Engineers Comments Regarding Surface Water Drainage

Application Reference:	P/40/25/PL	Reviewer Reference:	ADC/EXT4
Planning Officer:	Amber Willard	Date of Review:	17/12/2025
Site Name:	Sefter Farm Pagham Road Pagham PO21 3PX		
Application Description:	Erection of warehouse extension and remodelling of existing reservoir. This application is in CIL zone 5 (zero rated) and may affect the setting of a listed building.		
Assessment Number:	2 of 2

DRAWN A Davies
ENGINEER S Doughty
SCALE As Shown @ A1
DATE March 2025
CHECKED SRD
PROJECT NO. 23995
DRG. NO. 103
REV. -

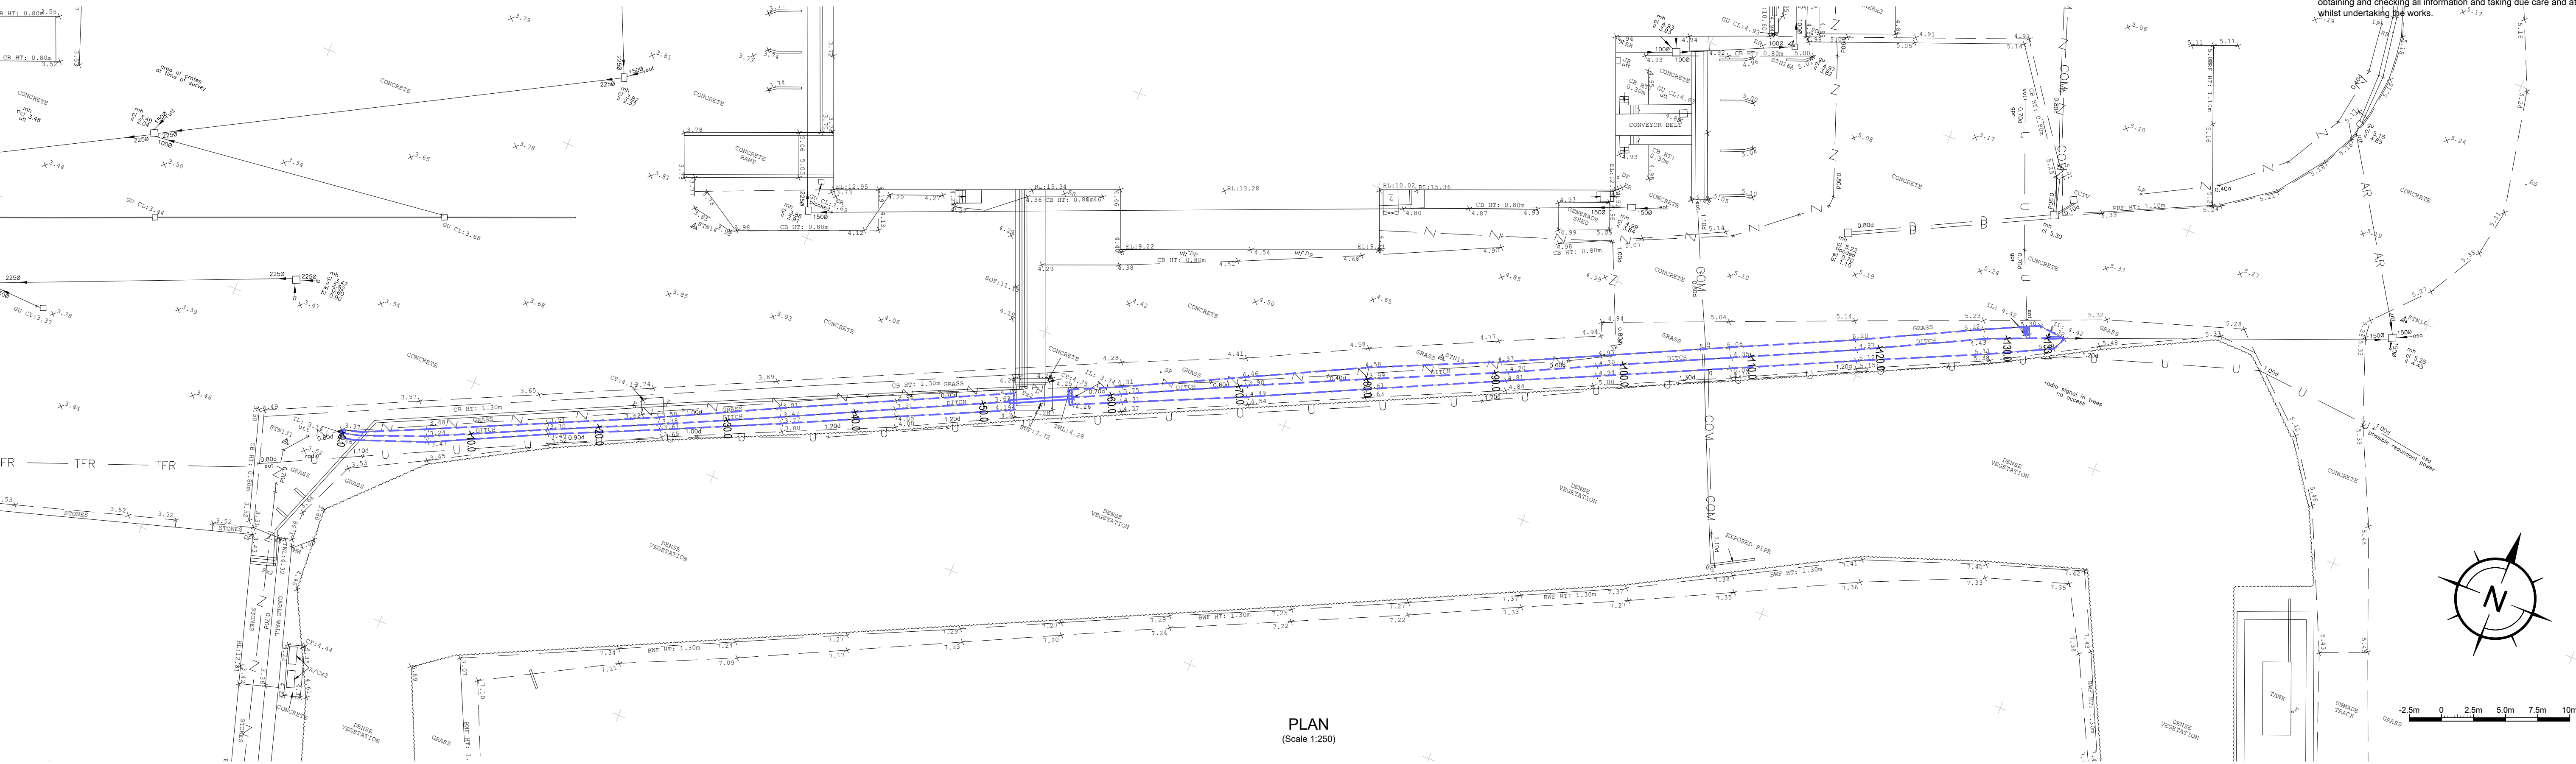
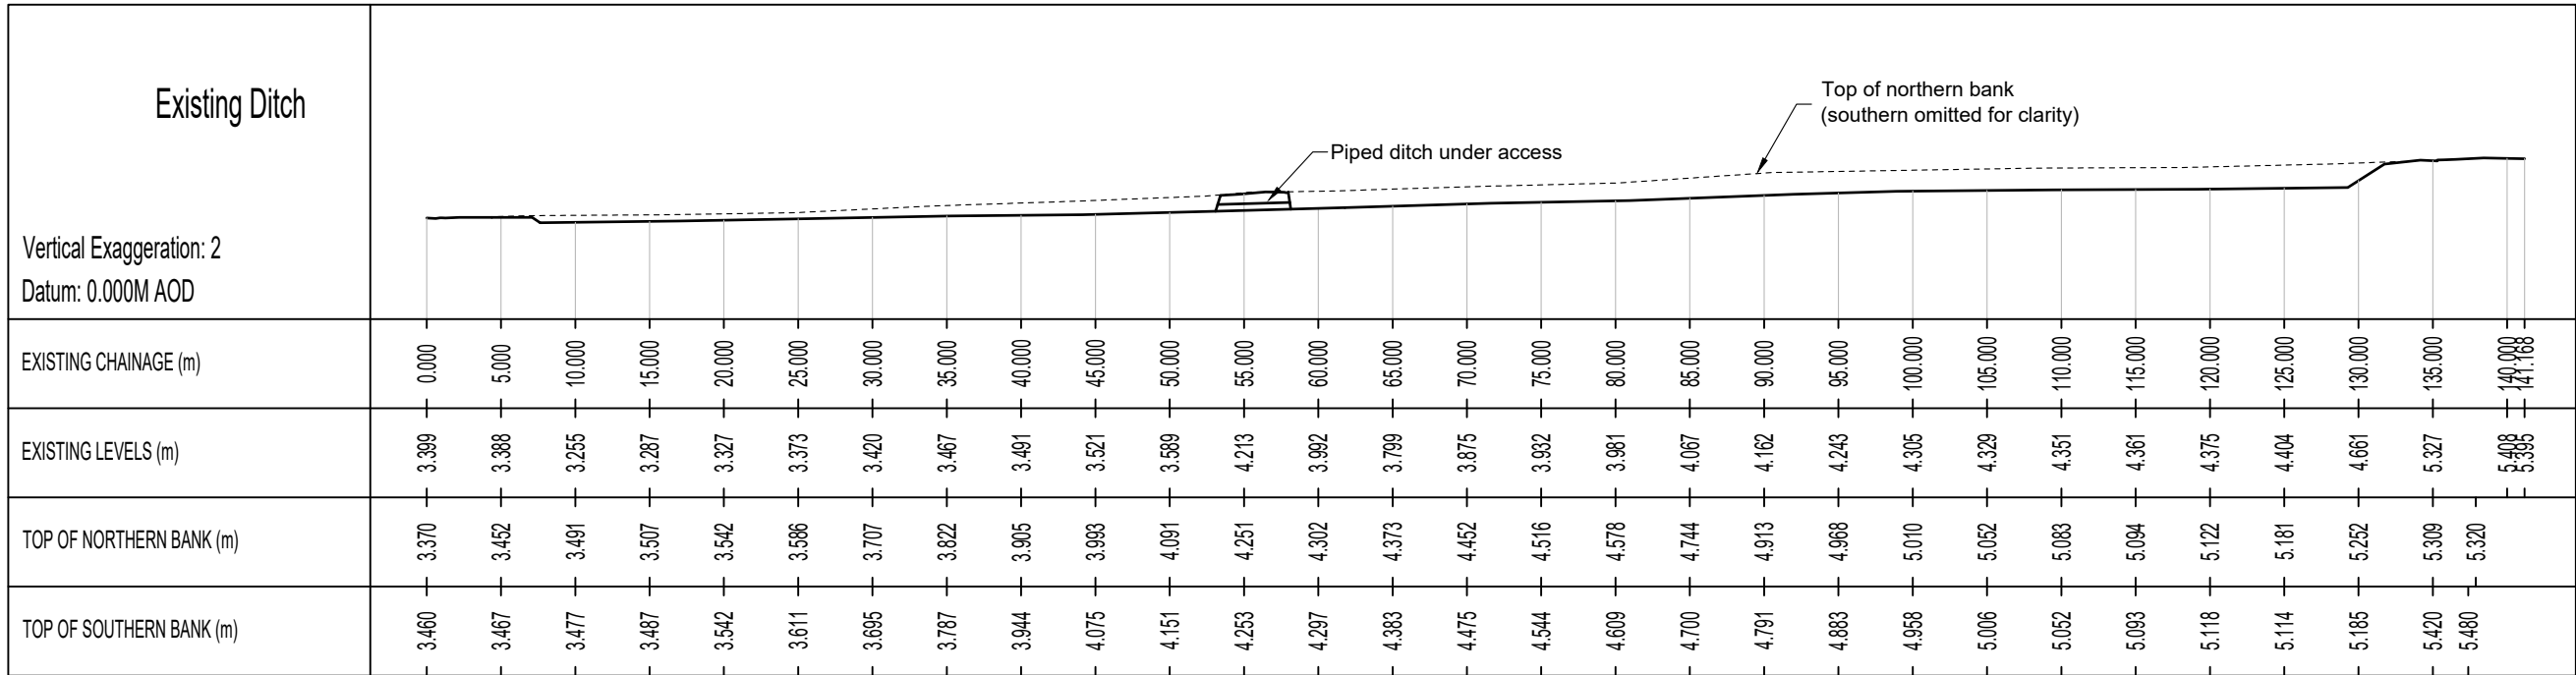
- 0.5. It is noted that there are proposals to divert the existing watercourse. Evidence of positive dialogue over these proposals with the LLFA is required to ensure that these proposals will be acceptable. The applicant will need to obtain an Ordinary Watercourse Consent in order to carry out any works or diversions to this existing watercourse

6.1. No assessment has been provided, though the diverted ditch does appear to provide an enhance and larger feature. Further supporting details should be provided
